TfNSW Ref: CD22/02550
Planning Portal Ref: SSD-14378717

SSD-14378717– Response to Submissions (RTS) for Telopea Concept Plan & Stage 1A Residential, Retail, Child Care and Aged Care, Adderton Road Telopea

DRAWING TITLE
STAGE 2 - BLDG. E
ELEVATIONS

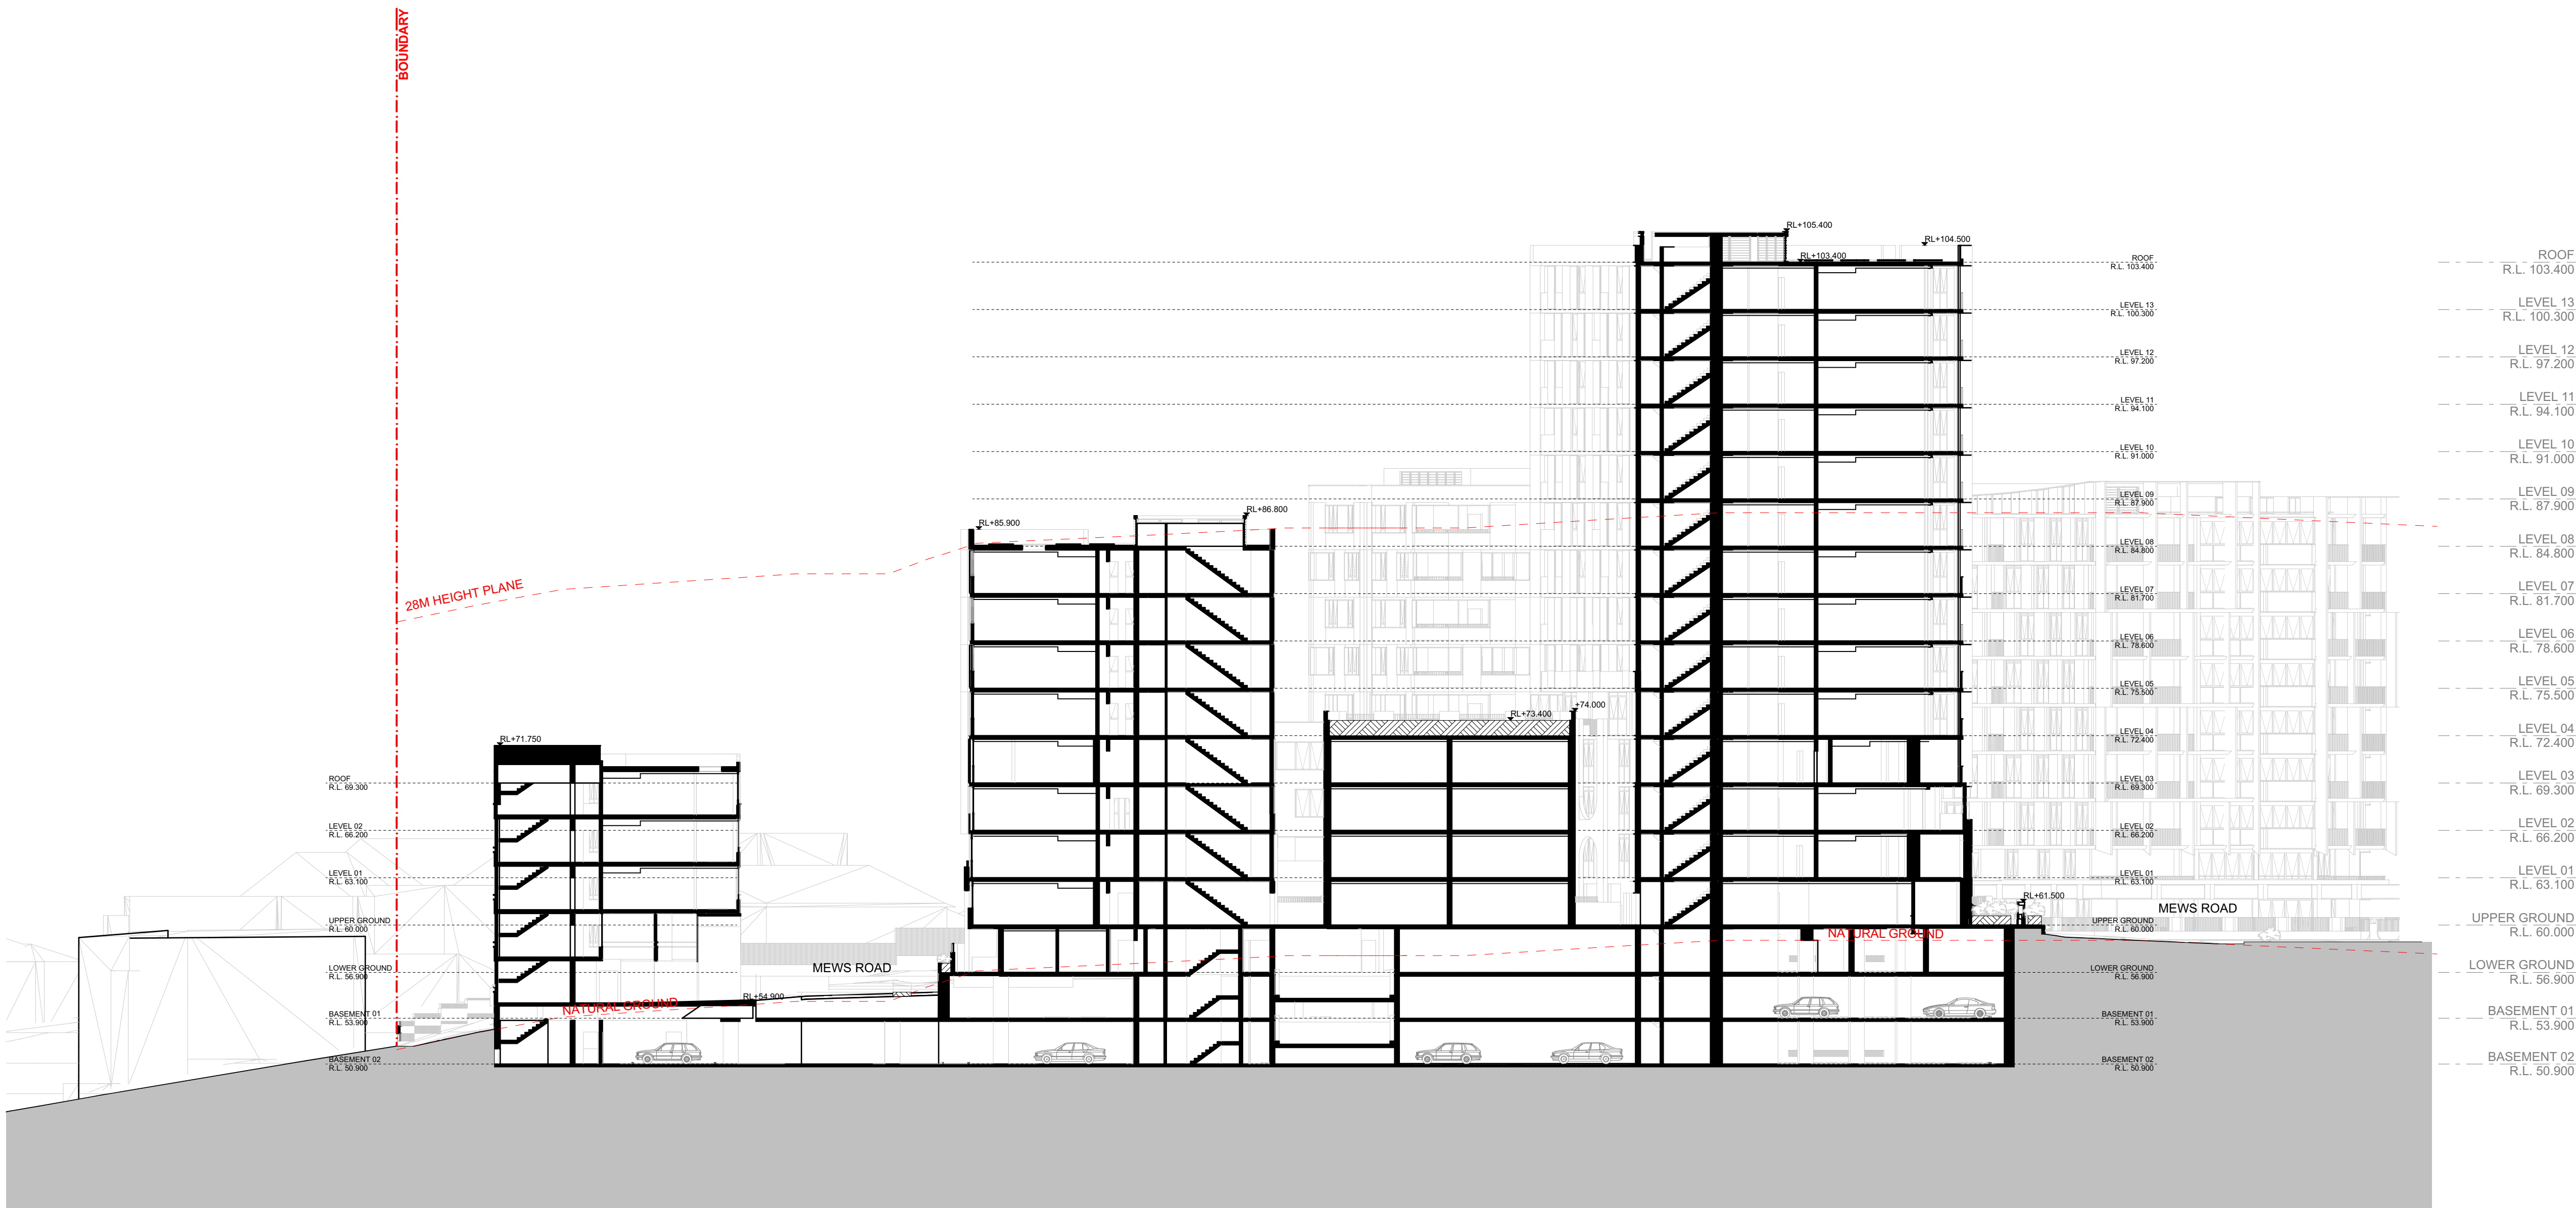
The design for openings such as balconies and windows on Building E will require risk mitigation of debris being thrown onto rail infrastructure. The Applicant was requested to provide updated

drawings/details for Building E, showing anti-throw mechanisms for openings etc. (windows, balconies, terraces, roof top facilities and the like) within 20m facing the rail corridor in accordance with protection of rail corridors in Asset Standards Authority (ASA) Technical Guidelines T HR CI 12090 ST and Development near Rail Corridors and Busy Roads – Interim Guideline.

- Prior to the issue of any construction certificate or any preparatory, demolition or excavation works, whichever is the earlier, the applicant shall provide updated drawings/details for Building E, showing anti-throw mechanisms for openings etc. (windows, balconies, terraces, roof top facilities and the like) within 20m facing the rail corridor in accordance with protection of rail corridors in Asset Standards Authority (ASA) Technical Guidelines T HR CI 12090 ST and Development near Rail Corridors and Busy Roads – Interim Guideline.
